TfNSW Reference: SYD19/01350/04

Departments Reference: SSD 10448

**ASPECTS INDUSTRIAL ESTATE – LOTS 54-58, DP259135 - MAMRE ROAD - KEMPS CREEK**

## **Attachment C – TfNSW Preliminary design comments – Mamre Road/Aspects Industrial Estate Access intersection**

Figure 19: Mamre Road & Site Access Ultimate Design

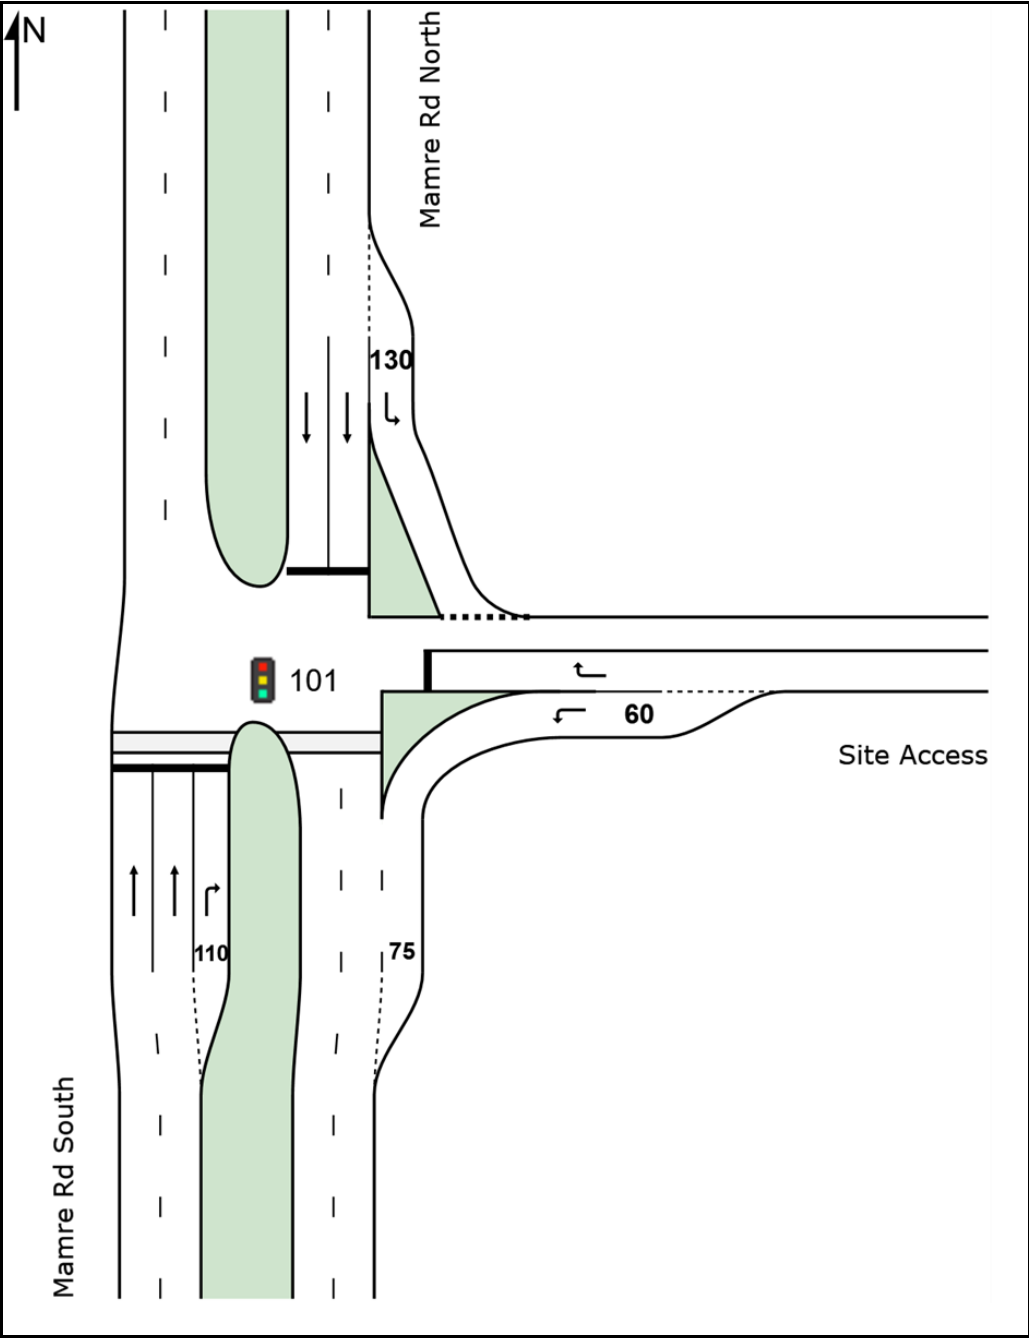
- 2.2. The proposed intersection in the Industrial Estate design does not appear to align with the TfNSW Mamre Road Upgrade design. Without the ability of overlaying both designs, it appears the deceleration lane and length do not alignment. The triangular medians also do not appear to align with the Mamre Road Upgrade design. The intersection should align with Mamre Road Upgrade design to minimise future disruption to the future operation of the Industrial estate. Updated plans should be provided which show that the design aligns with Mamre Road upgrade plans.

- 2.5. It appears the proposed Mamre Road alignment in the Industrial Estate maintains the current road alignment and not the future Mamre Road alignment. Design should consider future Mamre Road Upgrade design to assist with realigning the Mamre Road during the SEARS Aspect Industrial Estate development.

- 2.7. Additional design comments to be addressed:
    - 2.7.1. The four lanes proposed at the signalised intersection are required to be designed for a minimum of 200m form the intersection.

- 2.7.2. The cycle lane adjacent to the left turn lane and the acceleration lane should be removed and just have provision for cyclists adjacent to the median islands. The left turn lane should be 4.5m in width (this is to the face of kerb).

- 2.7.3. Clarification is required as whether the acceleration lane is warranted. Having acceleration lanes this short leads to unnecessary conflicts, especially when there is only one through lane. It is recommended that a standard high angle exit is considered (dependent on the traffic modelling outcomes).

- 2.7.4. There is no SA kerb, pram ramps or footpath shown on the western side. There should be at a minimum a 2.0m shoulder provided adjacent to the SA kerb on the western side.

- 2.7.8. Clarification is required as to whether Approach Sight Distance (ASD) is achieved for the traffic signals, from the northbound approach in particular.

- 2.7.9. On the new side road, there are two marked 'entry' lanes into the development. i.e. one for the left turners traveling south, and the right turners travelling north. Clarification is required as to the need for both lanes for such a short distance.
